CITY OF ALBUQUERQUE
MUNICIPAL DEVELOPMENT DEPARTMENT
ENGINEERING DIVISION/DESIGN HYDROLOGY SECTION

REF: HOOTEN OFFICE BLDG. (H19-D34)

A preliminary review of your submittal for building permit approval has shown that the following information is lacking for this section to begin the review process:

Re: Hooten Office Building (H19-034)

SITE PAVING & GRADING
C-2

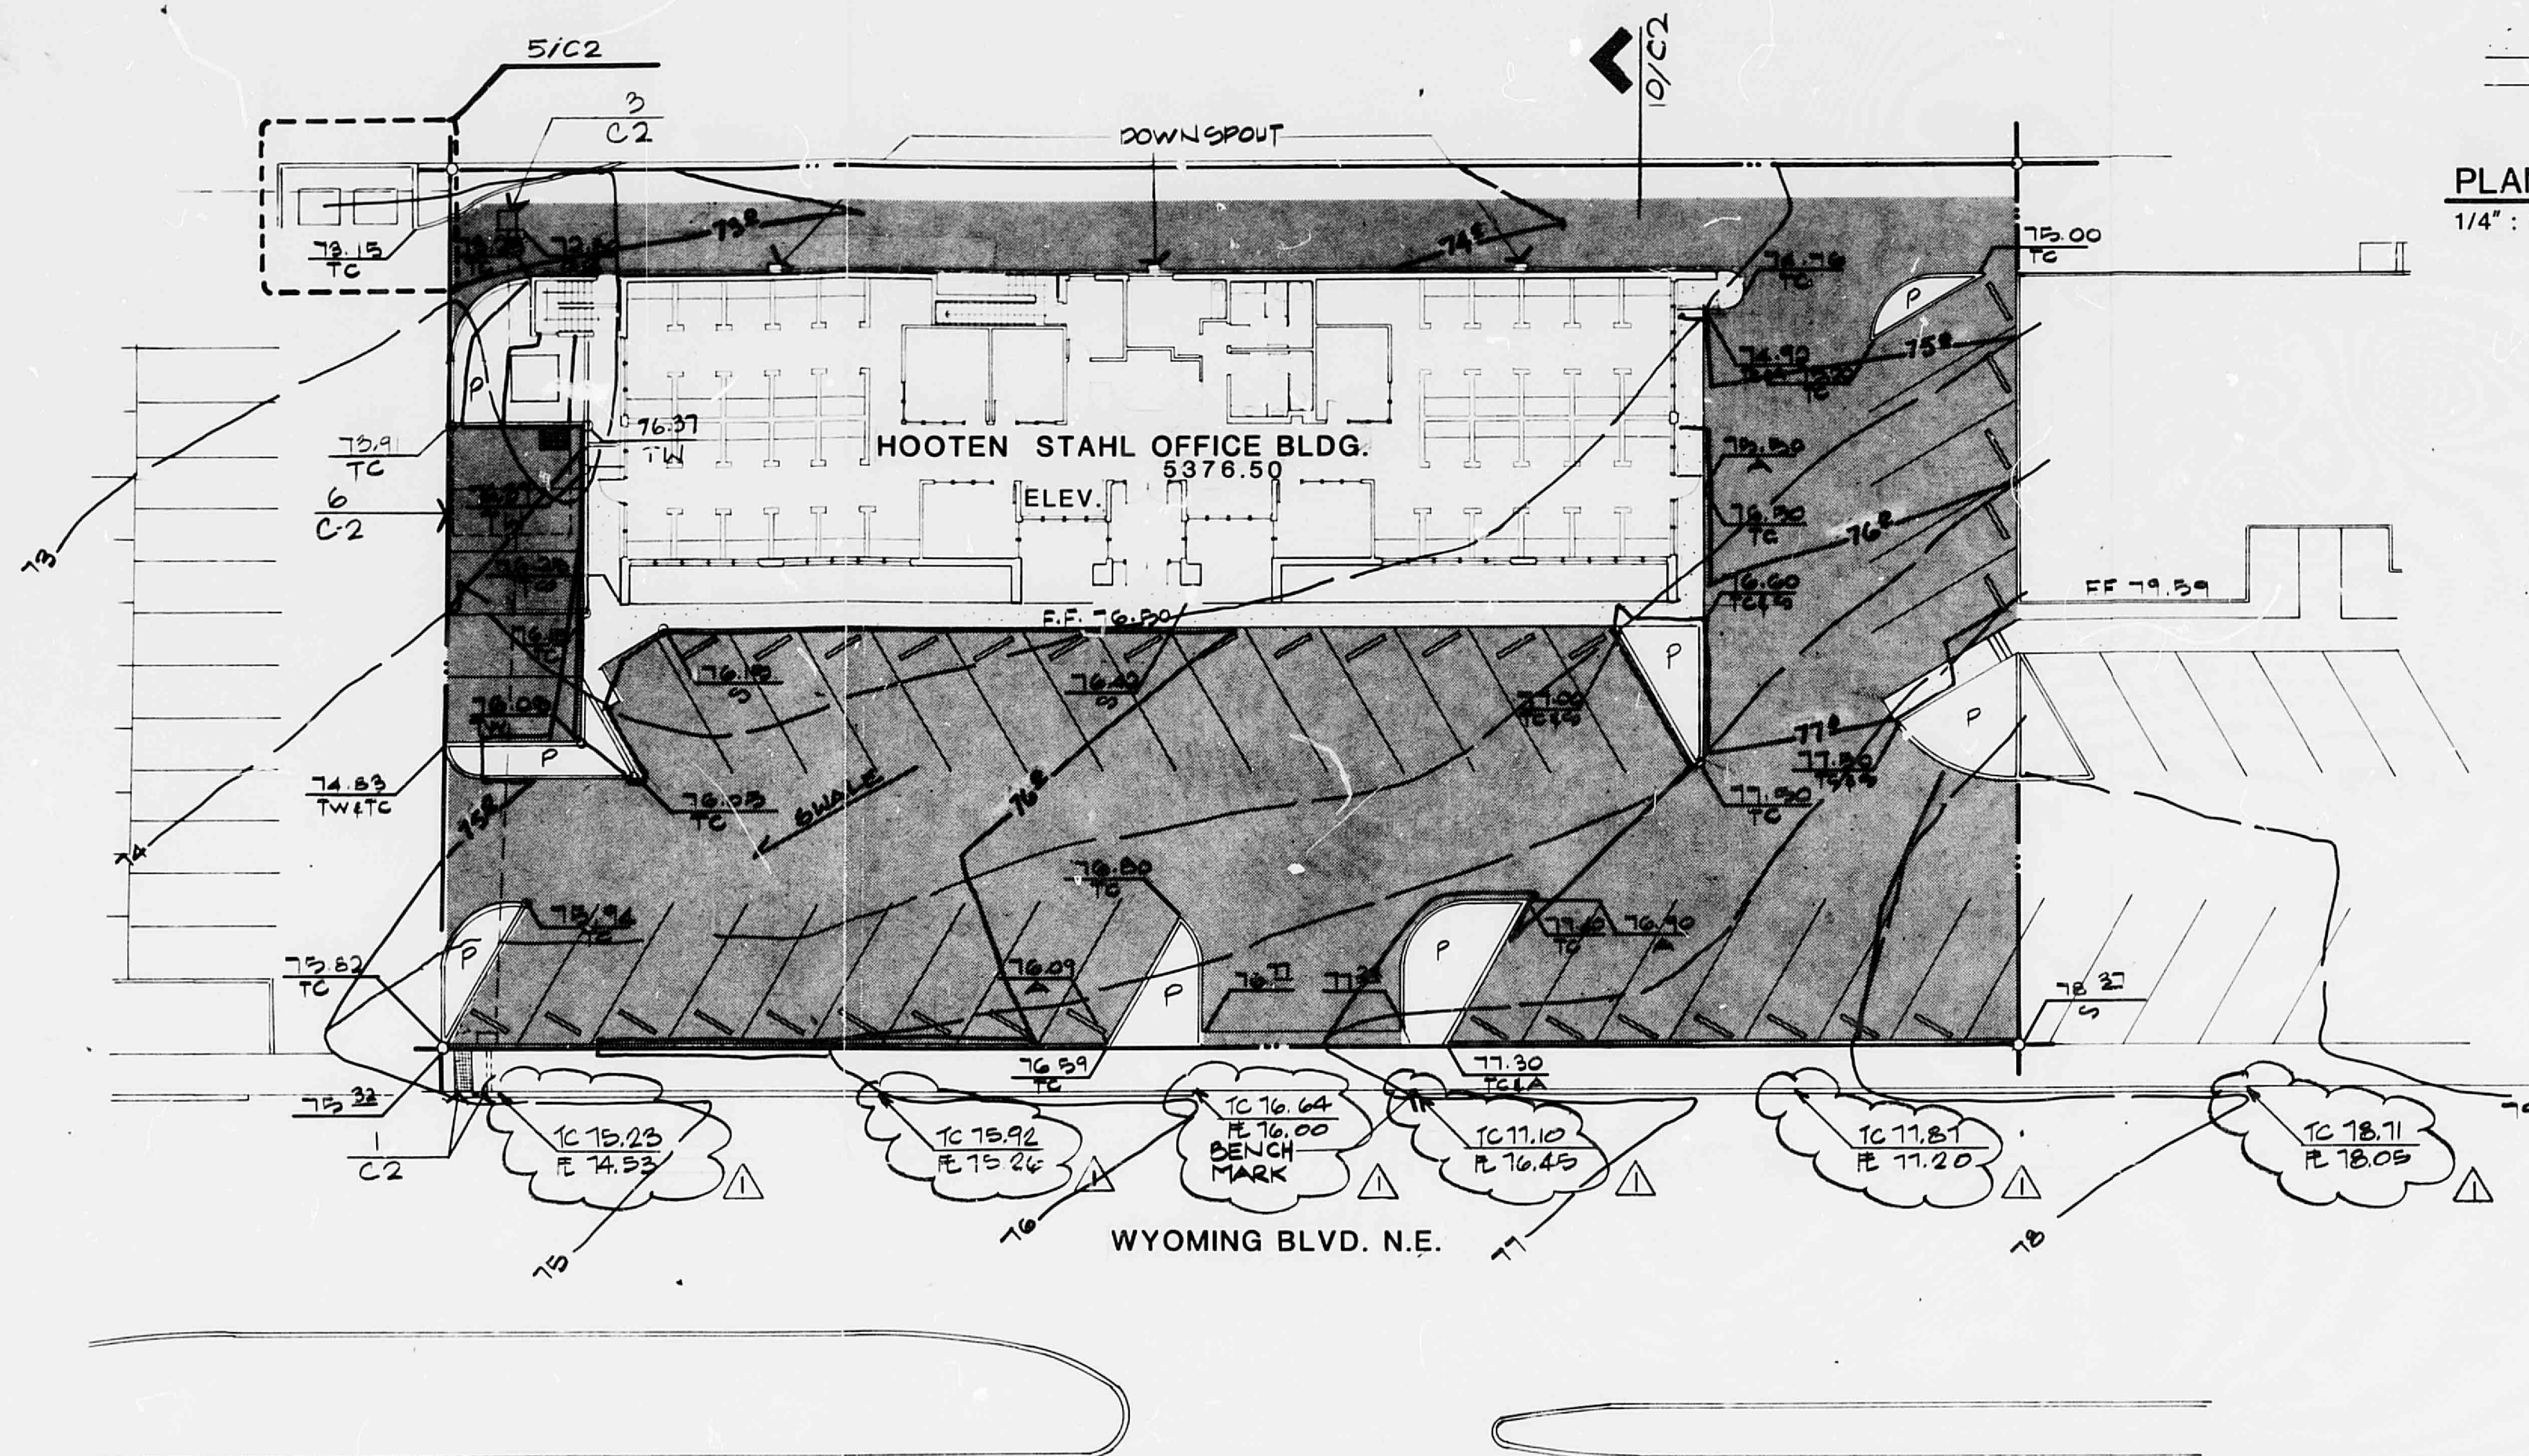
1. Vicinity map within plan drawing.
2. Bench Mark description/location, city Bench Mark used to design grades and set TBM.
3. Existing City top of curb and flow line elevations on or adjacent to site along Wyoming Blvd.
4. Erosion Control Plan required for duration of construction. What do you propose as far as erosion control.

Based on the information provided on your October 16, 1985 submittal, we will need a revision date with engineer's stamp on the plan drawing before approval is granted.

1. Vicinity map is on the drawing. Sheet C-2.
2. City bench mark information has been placed on the drawing.
3. Existing curb and flow line elevations have been shown on the drawing.
4. Erosion control during construction will be provided by constructing the retention pond and appurtenances at the beginning of the project. A temporary earth berm will be constructed along Wyoming Blvd. to control sheet flow until permanent paving is in place.

We are sending a new submittal of Sheet C-2. Please call me if further information is required.
